Subject  
**Expert Peer Review – Santos Narrabri Gas Project**

21 June 2018  
UniQuest Project No: C03243-001

Expert Peer Review – Santos Narrabri Gas Project

The Aboriginal cultural heritage zoning scheme is illustrated in the sensitivity mapping in Figure 20-2.

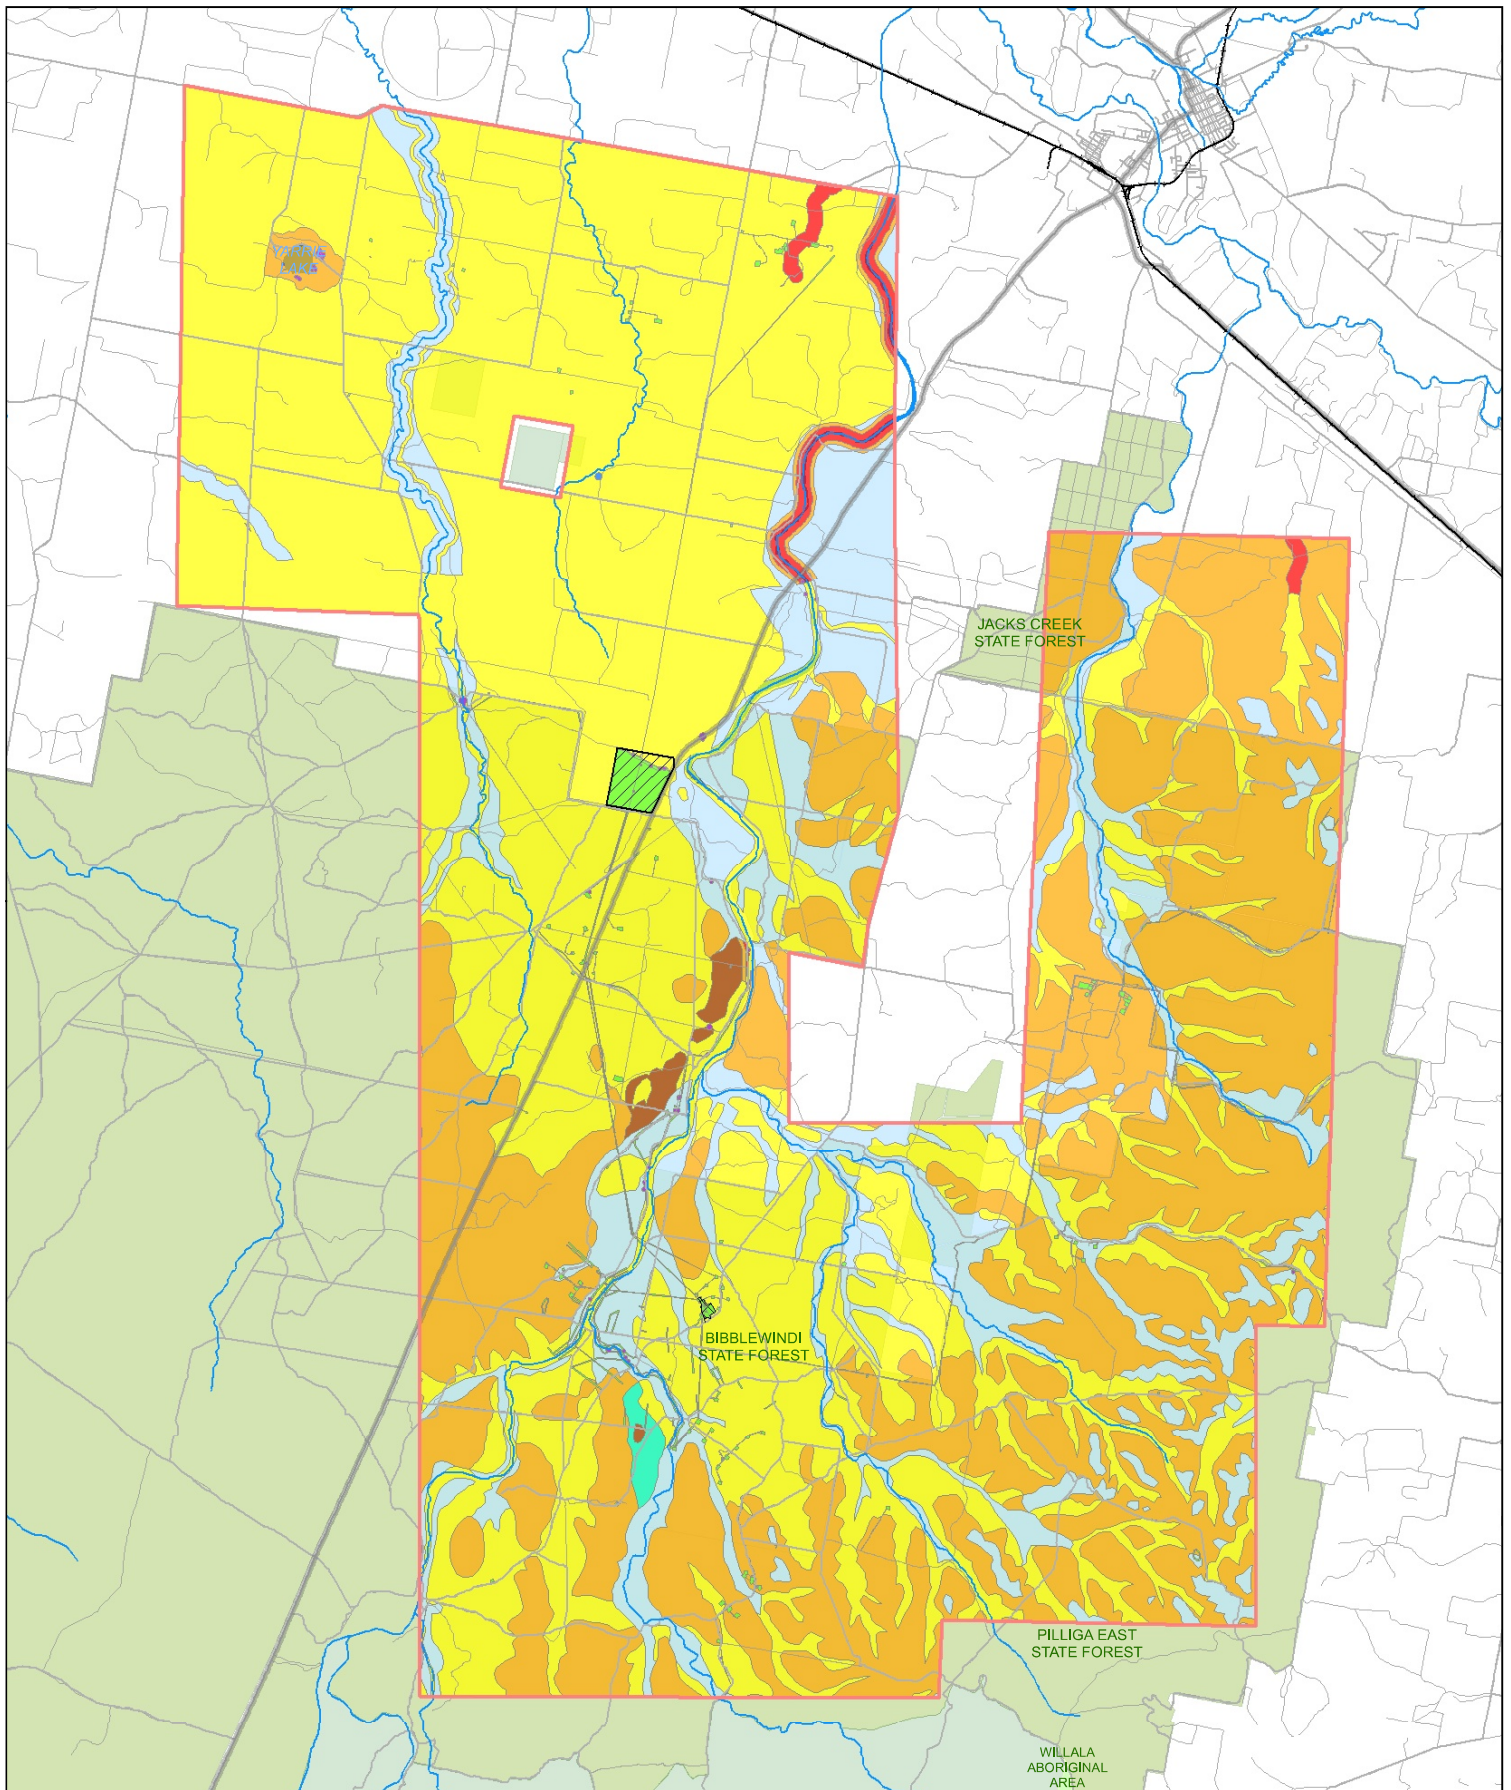
However, the sensitivity mapping would form the baseline against which future data would be collected. Further, it is the basis of some of the methodologies presented in Section 4.8 of the CHMP. Therefore, it is important to note (as the ACHA itself does) that the sensitivity mapping presented in the ACHA has serious limitations. For example, in addition to the limitations that the ACHA identifies, other inconsistencies are apparent:

- By reference to the ACHA's own data, when previously recorded Aboriginal sites are overlaid on the ACHA's sensitivity map, a large proportion of previously identified sites are located in areas identified by the ACHA as being of 'low sensitivity'. Conversely, areas identified by the ACHA as being of high sensitivity actually contain only a small number of previously recorded sites – see, for example, the following image which depicts known Aboriginal cultural heritage from the AHIMS database (blue dots), in the north-eastern corner of the project area, with yellow being areas of low sensitivity and orange being areas of high sensitivity.

- The rationale for the selection and non-selection of certain variables typically useful to the generation of a Cultural Heritage Zoning Scheme (CHZS) and sensitivity maps is not entirely clear in the ACHA. For example, given the level of detailed data available in relation to geology and ecology, it is not clear why no attempt was made to refine the sensitivity maps to test for, for example, potential for quarries (correlates with geology), potential for grinding areas (correlates with geology and water), and potential scarred trees (correlates with vegetation patterns).

- One variable utilised in the production of the sensitivity map is landform system. This is appropriate; however, the Applicant states that some landform units are overrepresented in terms of previous studies of cultural heritage, and some under-represented. For example, in Table 4-9 of the ACHA, Gilgai Landform Units are assessed as being of 'Low' sensitivity. However, the Applicant states that these landforms are 'known to be important sources of seasonal/ephemeral water'. The precautionary principle would require a more cautious assessment of Gilgai landform units (e.g. making them of high significance) until further survey has been undertaken, and additional data gathered, to test that assessment.

- The sensitivity mapping in the ACHA reaches conclusions about the proximity of Aboriginal sites to water, specifically by reference to stream order. These conclusions are somewhat

In the interim the sensitivity zones should be used with caution, including with respect to the methodologies presented in Section 4.8 of the CHMP. They should be refined as additional data are generated.
